AKD/KT
14487
18 May 2016

**SECTION 96(1A) - MODIFICATION APPLICATION TO SSD 6840
ST VINCENT'S PRIVATE HOSPITAL SYDNEY**

On behalf of St Vincent's Private Hospital Sydney (SVPHS), we hereby submit an application pursuant to section 96(1A) of the *Environmental Planning and Assessment Act, 1979* (EP&A Act) to modify Development Consent SSD 6840 relating to the approval of the East Wing building and the SVPHS high-rise building located within the St Vincent's Hospital campus (the site).

GA PLAN, LEVEL 08

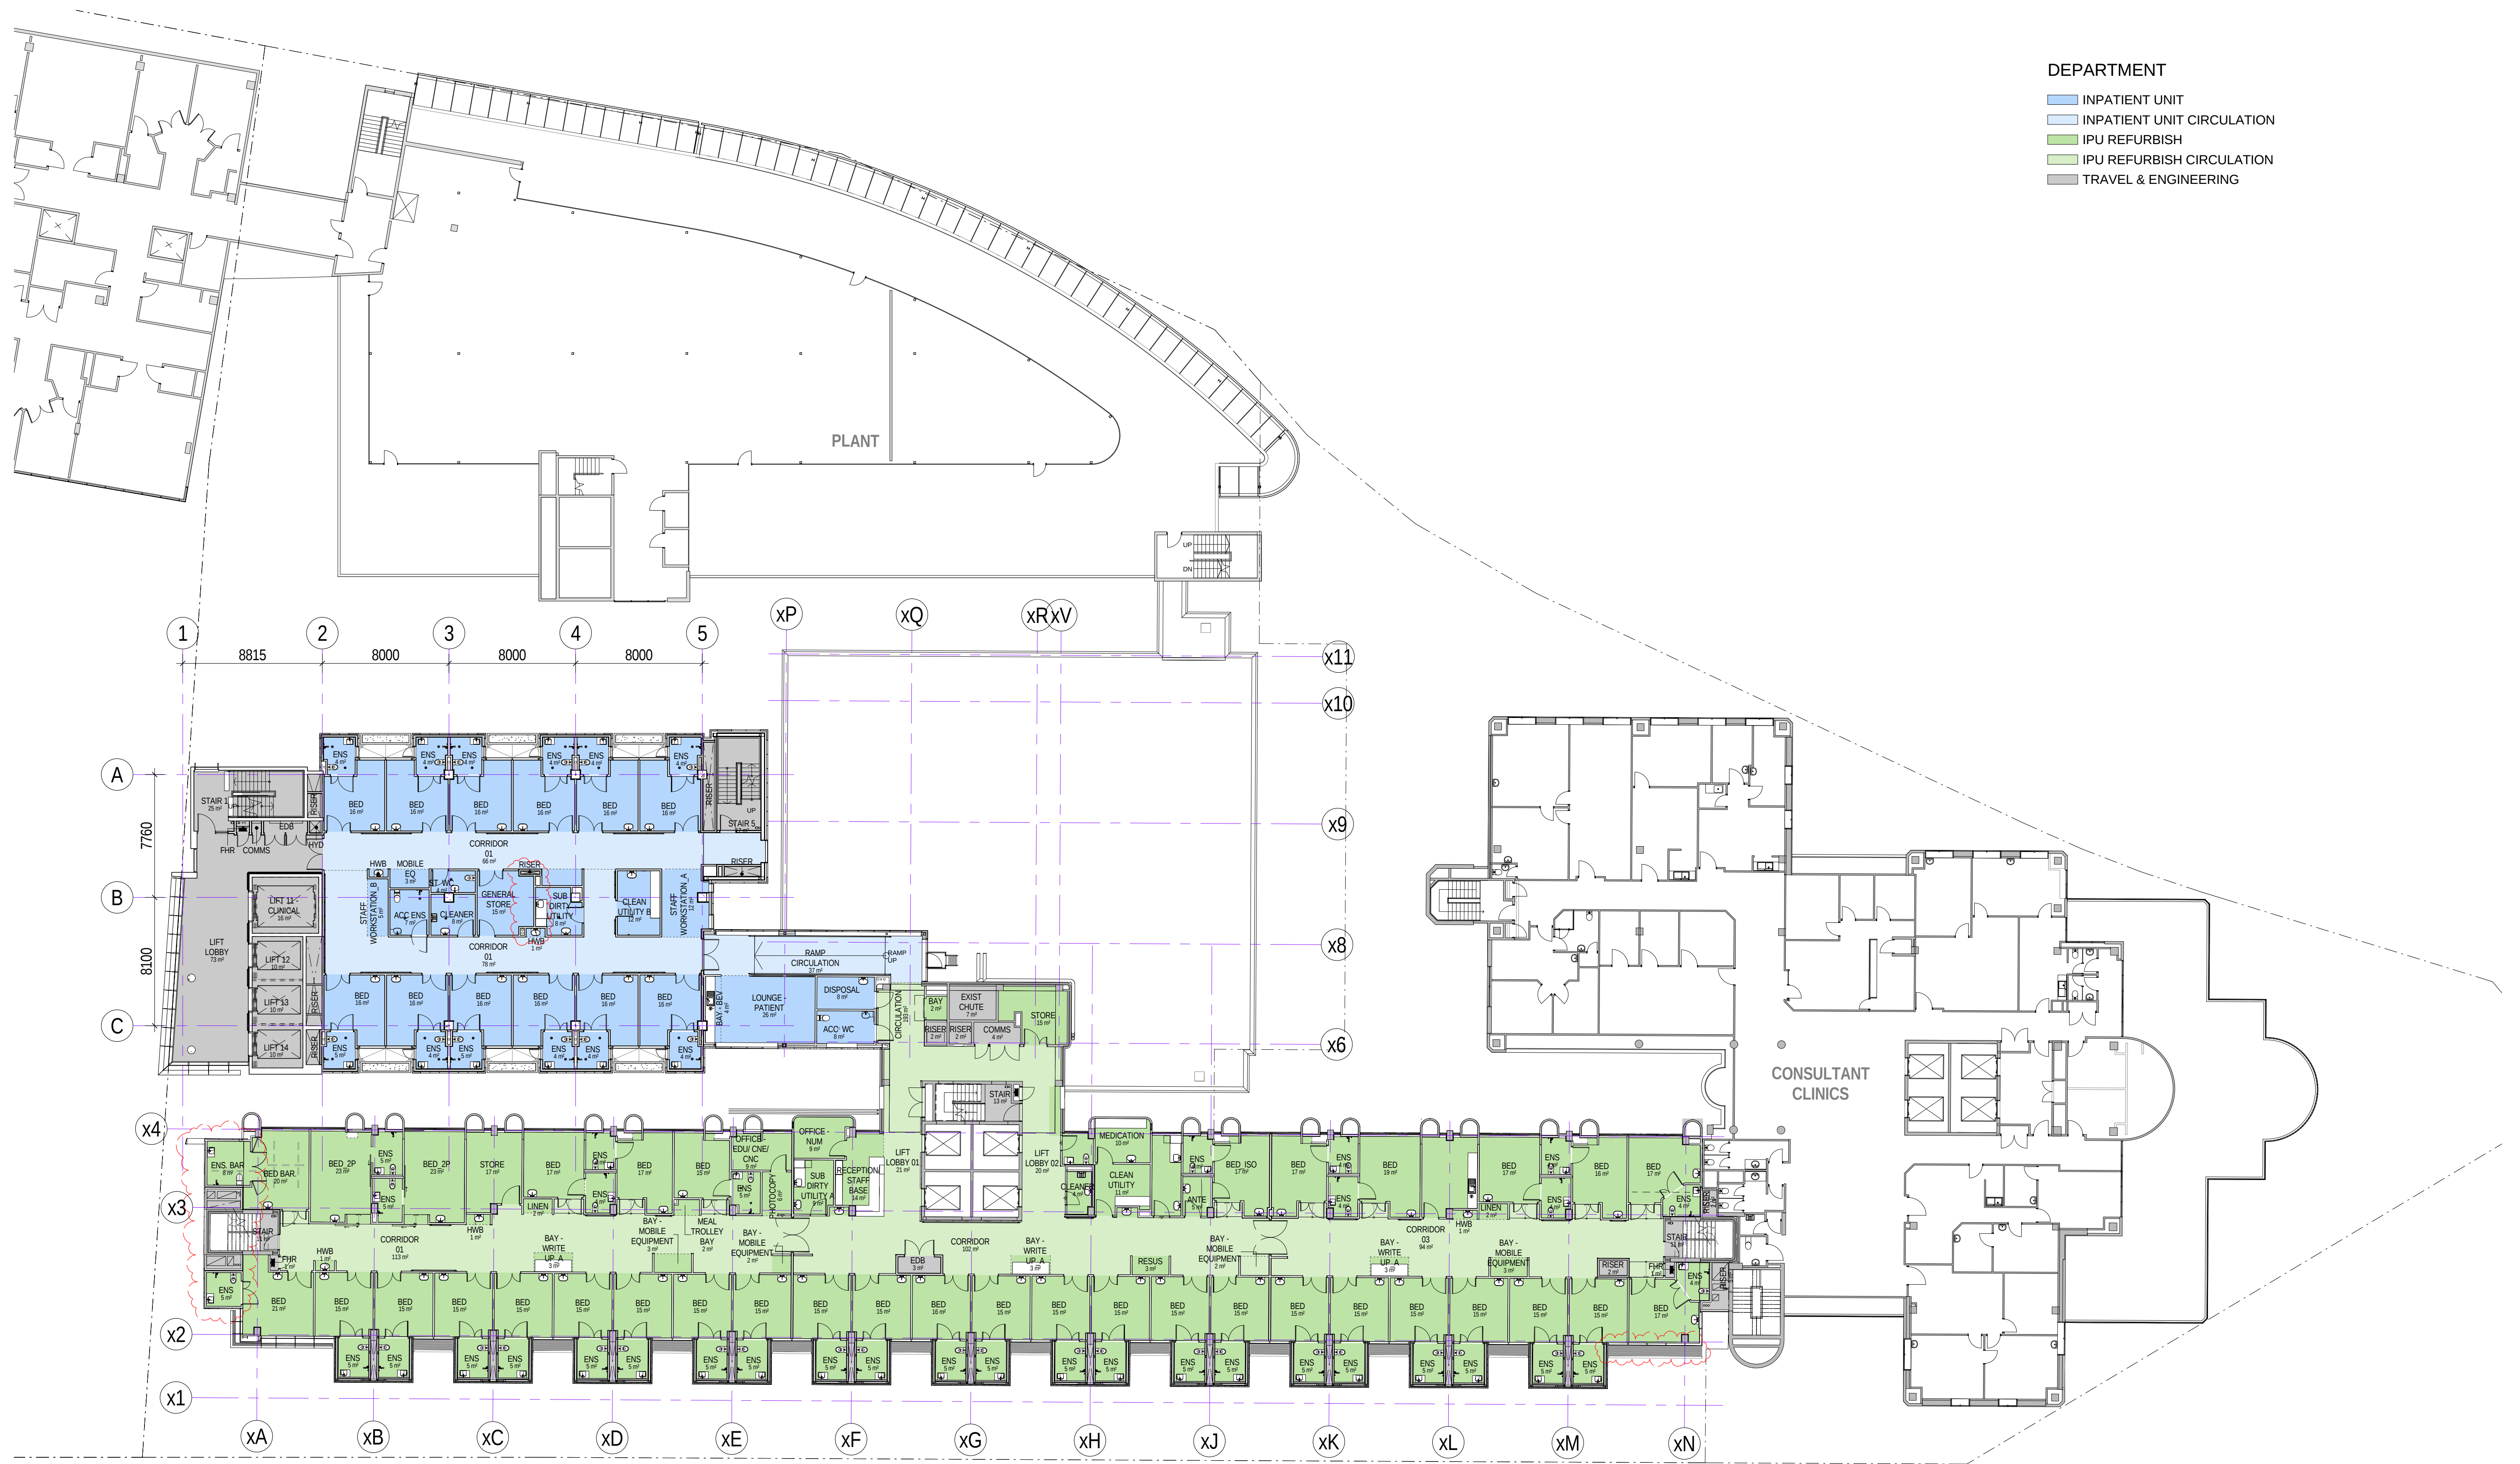
GA Plan – Level 03	<ul style="list-style-type: none"> ■ No change. 	DA-01-003	D
GA Plan – Level 04	<ul style="list-style-type: none"> ■ Minor reconfiguration of the internal layout. 	DA-01-004	E
GA Plan – Level 05	<ul style="list-style-type: none"> ■ Infill of the existing void; and ■ Increase in the size of the hoist. 	DA-01-005	F
GA Plan – Level 06	<ul style="list-style-type: none"> ■ Increase in the size of the ensuites to the north elevation of the high rise wing. 	DA-01-006	E
GA Plan – Level 07	<ul style="list-style-type: none"> ■ Inclusion of additional planter boxes; ■ Amendments to the façade line; ■ Increase in the size of the hoist; and ■ Increase in the size of the ensuites to the north elevation of the high rise wing. 	DA-01-007	E
GA Plan – Level 08	<ul style="list-style-type: none"> ■ Increase in the size of the hoist; ■ Increase in the extent of stair 5; and ■ Increase in the size of the ensuites to the north elevation of the high 	DA-01-008	F

Drawing  
DA-01-010  
Level  
L10  
Region  
OA

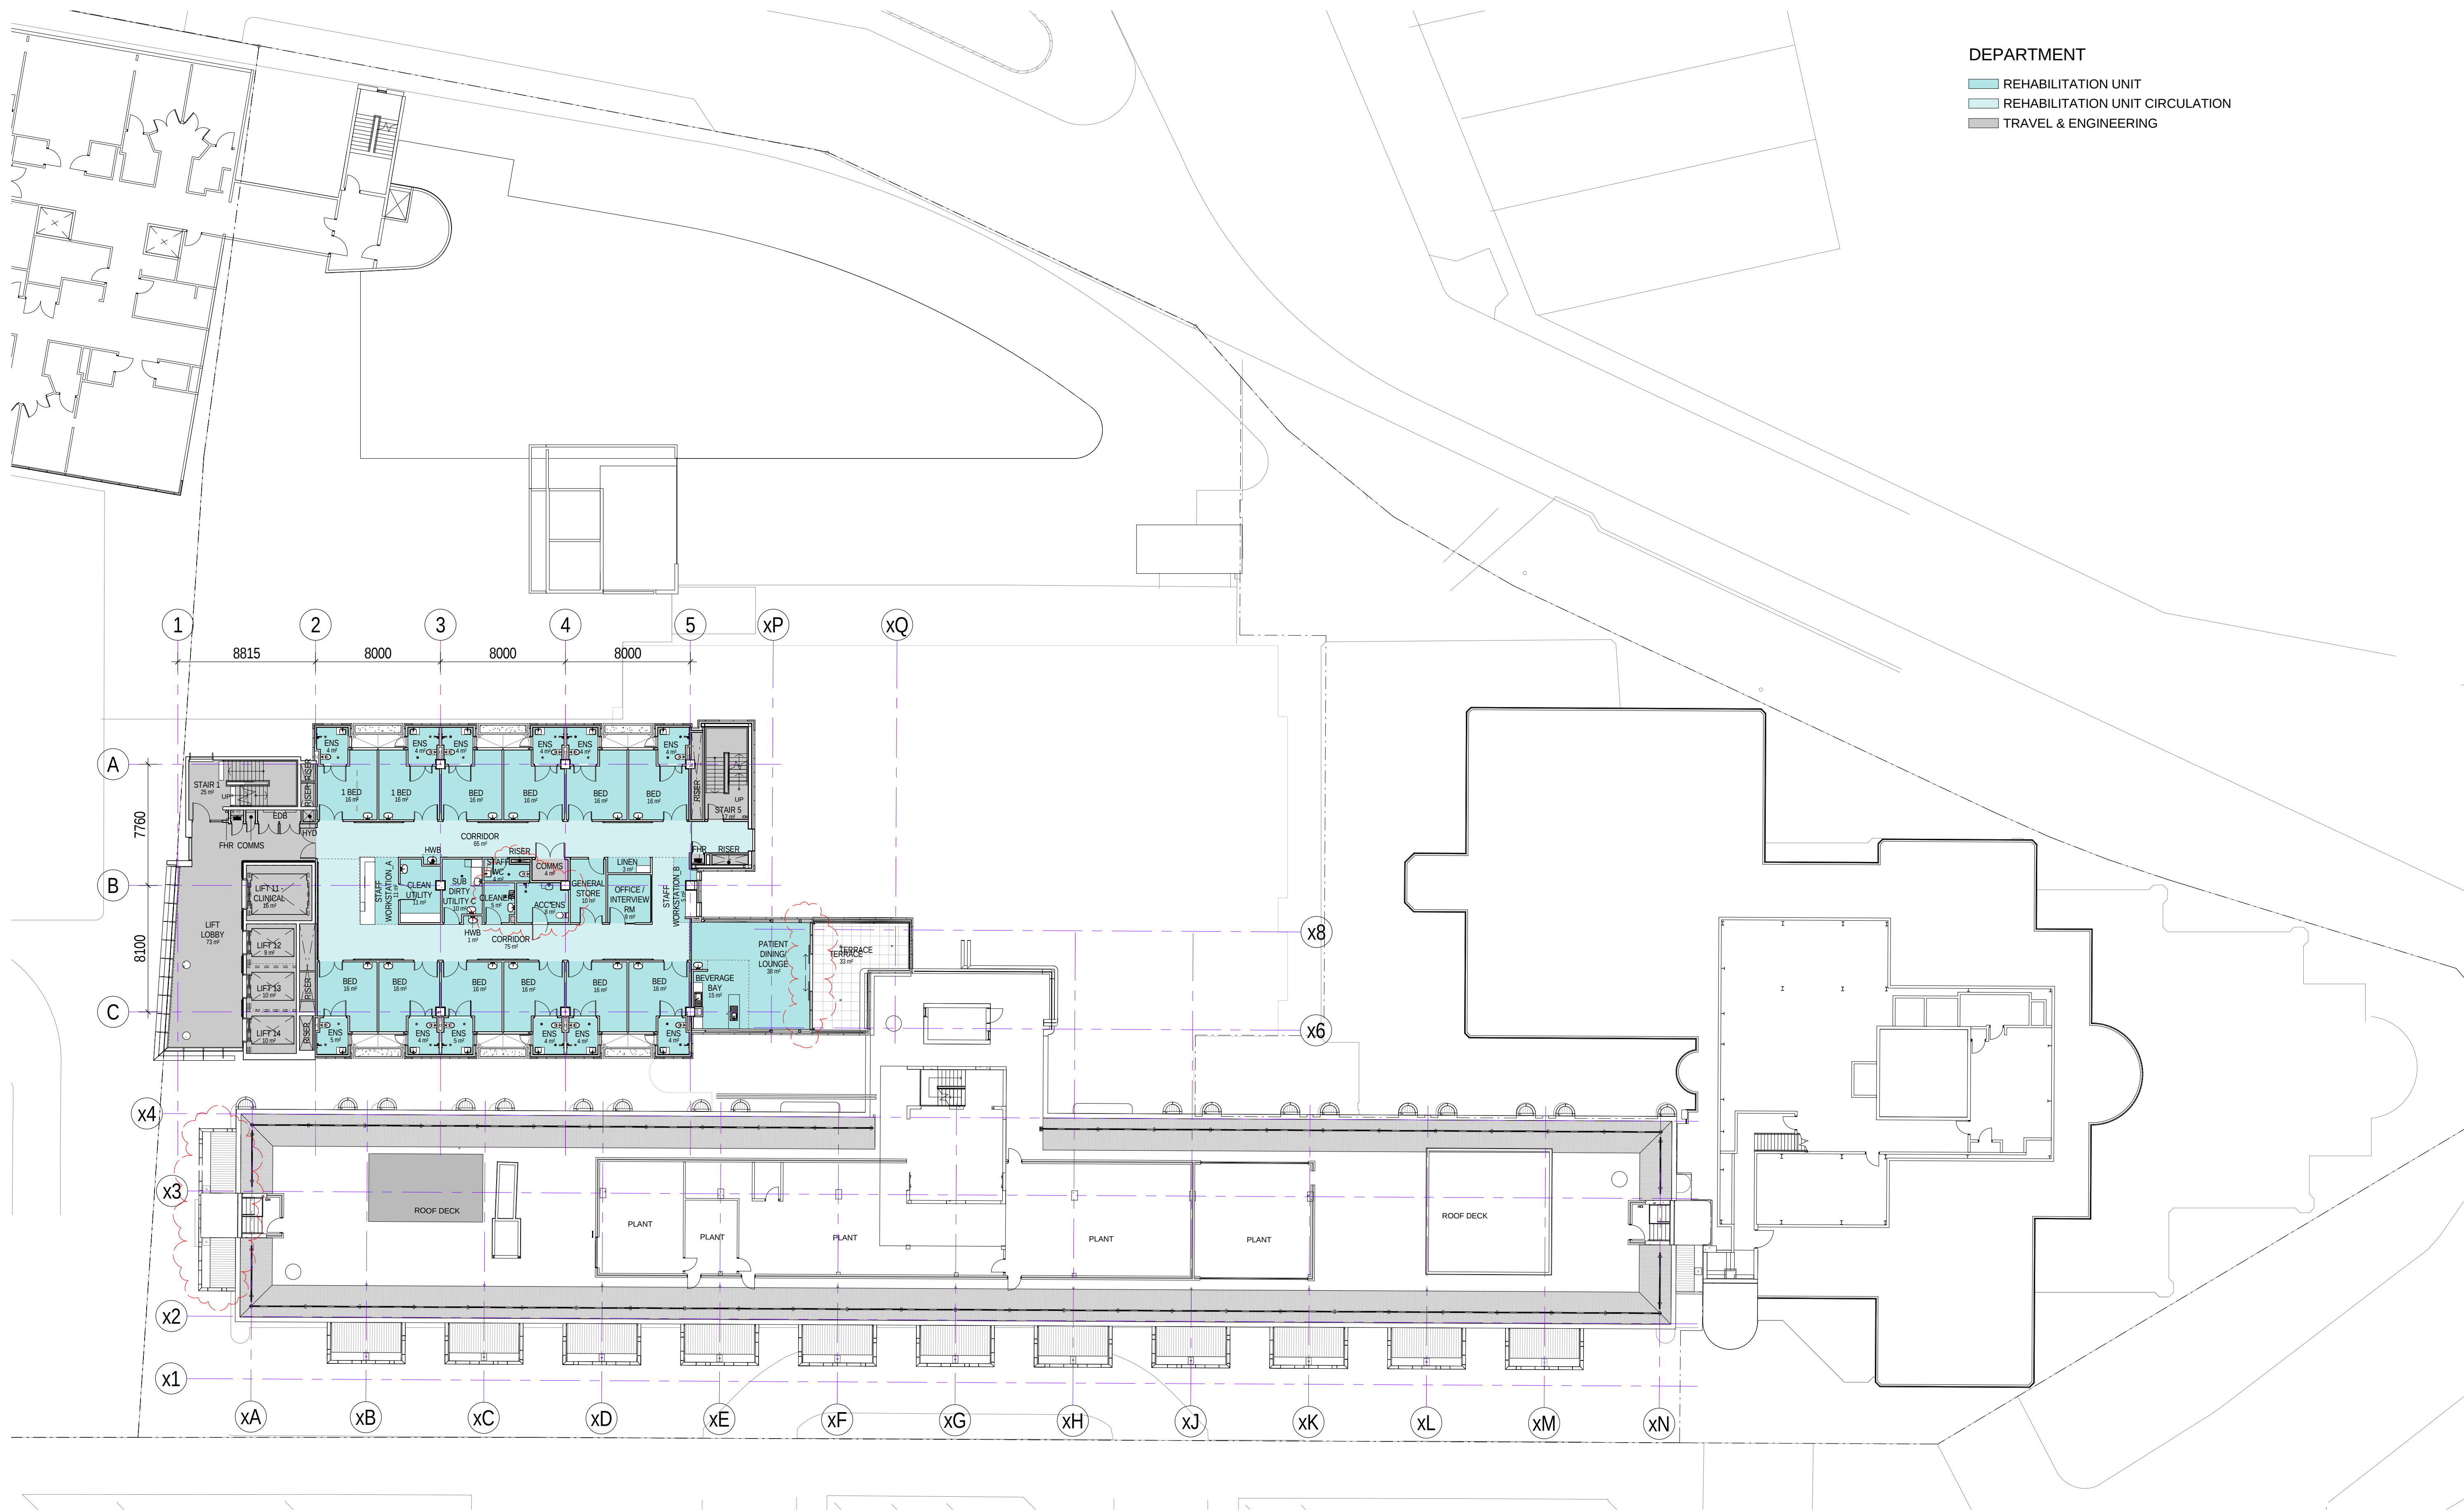
Level	Description of Proposed Modification	Drawing No.	Revision
	rise wing and East Wing Building.		
GA Plan – Level 09	<ul style="list-style-type: none"> ▪ Increase in the size of the hoist; ▪ Inclusion of additional plant on the CSSD roof (low-rise building); ▪ Increase in the extent of stair 5; and ▪ Increase in the size of the ensuites to the north elevation of the high rise wing and East Wing Building. 	DA-01-009	F
GA Plan – Level 10	<ul style="list-style-type: none"> ▪ Increase in the extent of stair 5; and ▪ Increase in the size of the ensuites to the north elevation of the high rise wing and East Wing Building. 	DA-01-010	F
GA Plan – Level 11	<ul style="list-style-type: none"> ▪ Incorporation of a sliding door to the terrace; ▪ Increase in the extent of stair 5; and ▪ Increase in the size of the ensuites to the north elevation of the East Wing building. 	DA-01-011-L11-OA	F
GA Plan – Level 12	<ul style="list-style-type: none"> ▪ Increase in the extent of stair 5; and ▪ Introduction of a split floor level. 	DA-01-012	F

GA PLAN. LEVEL 13

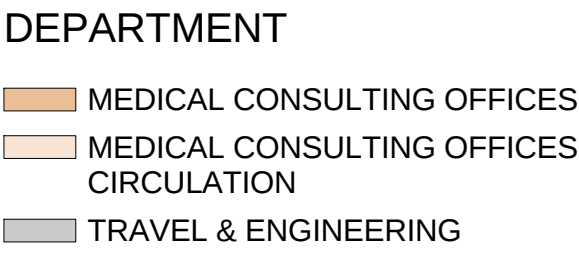
GA Plan – Level 13	<ul style="list-style-type: none"> ▪ Increase in the extent of stair 5. 	DA-01-013	E
GA Plan – Level 14	<ul style="list-style-type: none"> ▪ Increase in the extent of stair 5. 	DA-01-014	E
GA Plan – Level 15	<ul style="list-style-type: none"> ▪ Inclusion of additional meeting room; ▪ Increase in the extent of stair 5; and ▪ Minor amendments to the layout and extent of plant enclosure. 	DA-01-015	F
Victoria Street Elevation	<ul style="list-style-type: none"> ▪ Vertical extensions to ensuites. 	DA-03-001	E
East Wing – West Elevation	<ul style="list-style-type: none"> ▪ Increases and reductions to the floor to floor levels to accommodate the previously approved hydrotherapy pool and inclusion of a split level on Level 12; ▪ Deletion of the high level windows to the ensuites of the high rise building; ▪ Removal of the business identification sign comprising the St Vincent's Hospital logo; ▪ Amendments to the vertical shading design on the East Wing building to increase the extent of the glazing; ▪ Realignment of the spandrel panel to reflect the inclusion of a split level on Level 12; ▪ Reduction in the height of the lift shaft; and ▪ Minor amendments to the materiality of the building. 	DA-03-002	E

Figure 2 – Approved design (above) and proposed split level (below)

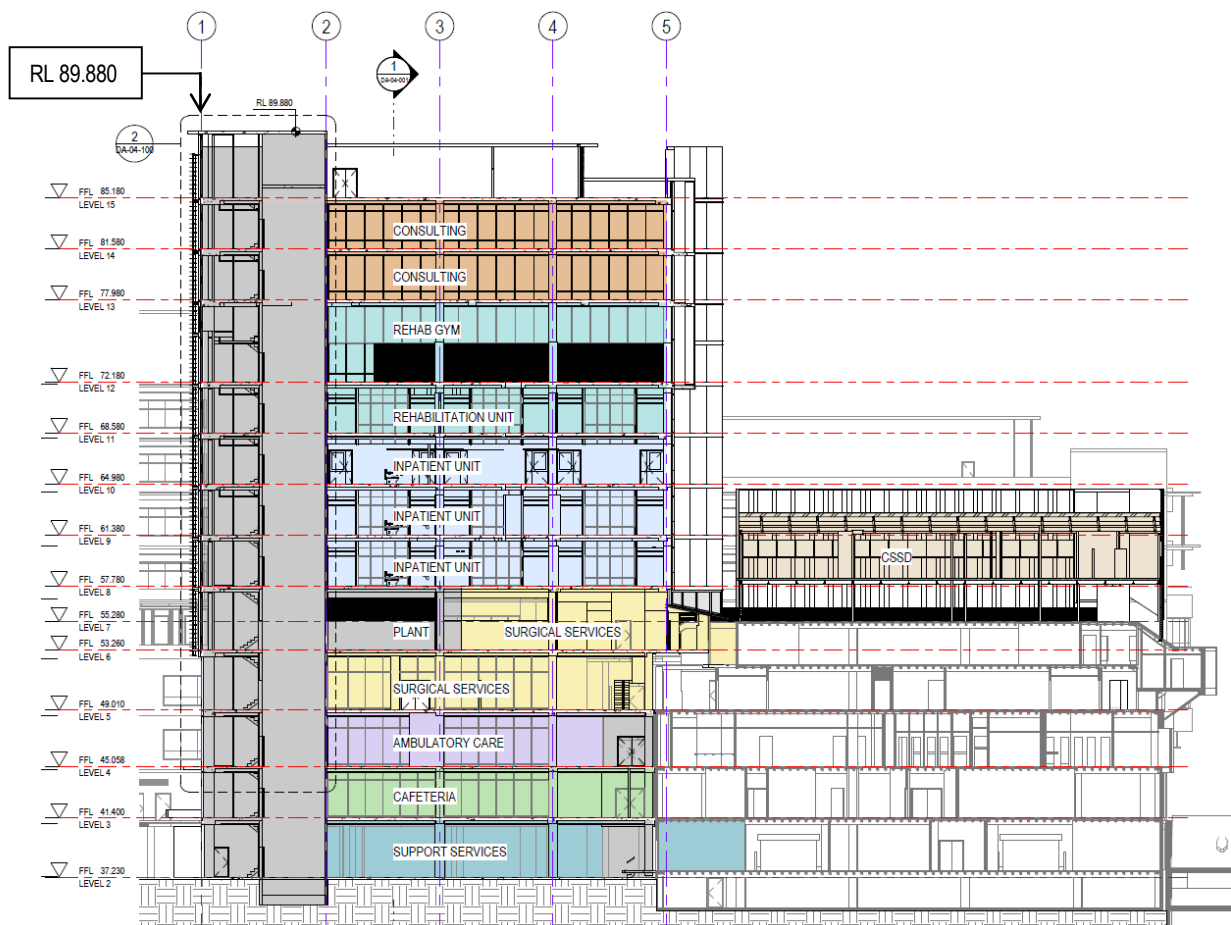
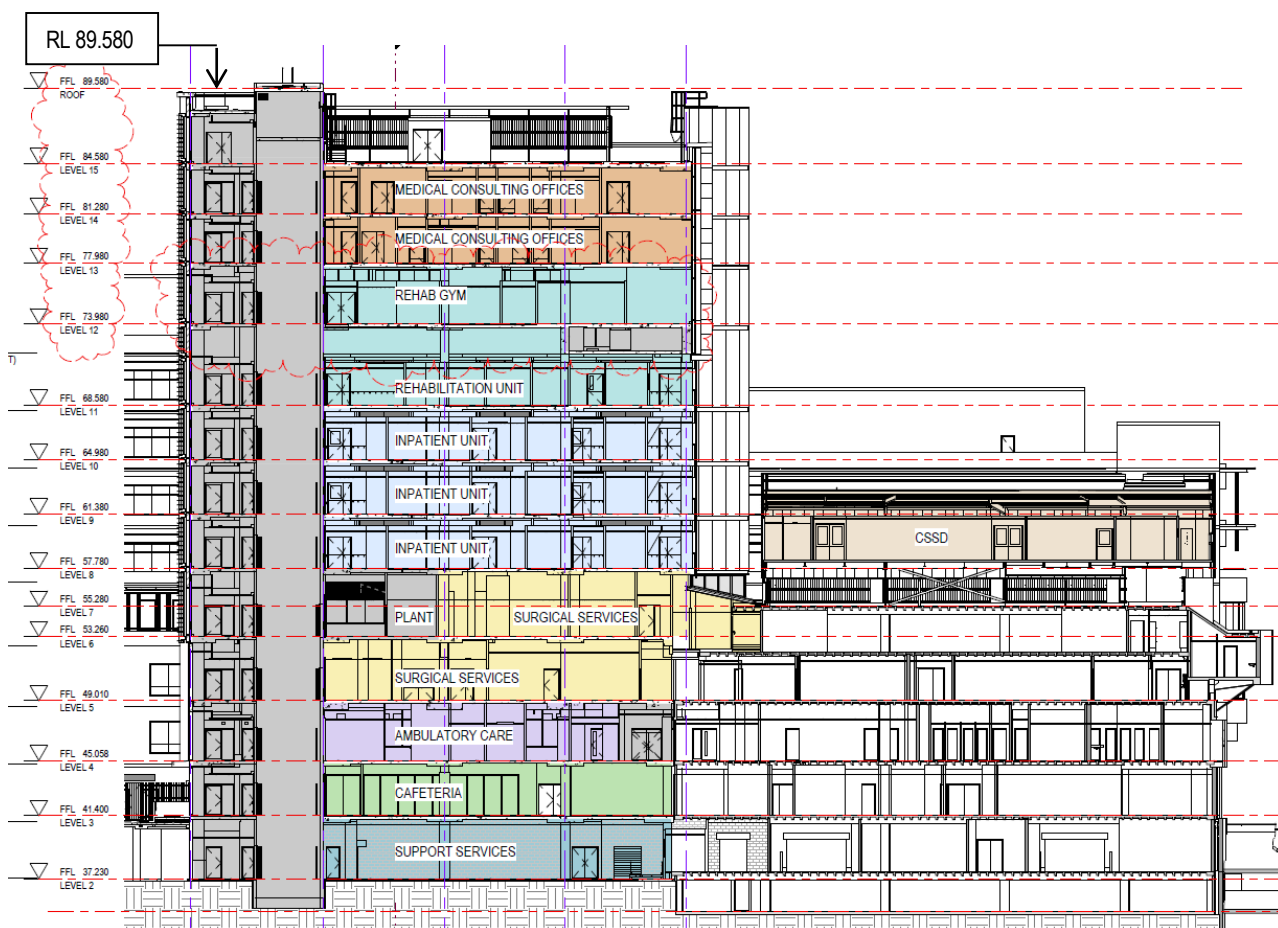
Amendments to the floor to floor heights are required to accommodate the aforementioned split level on Level 12 and the previously approved hydrotherapy pool. Whilst increases to the floor to floor heights are proposed on Level 12, those on Levels 14 and 15 have been reduced to maintain consistency with the building's approved height. The proposed changes are illustrated below in **Figure 2** and are detailed in **Table 2**.
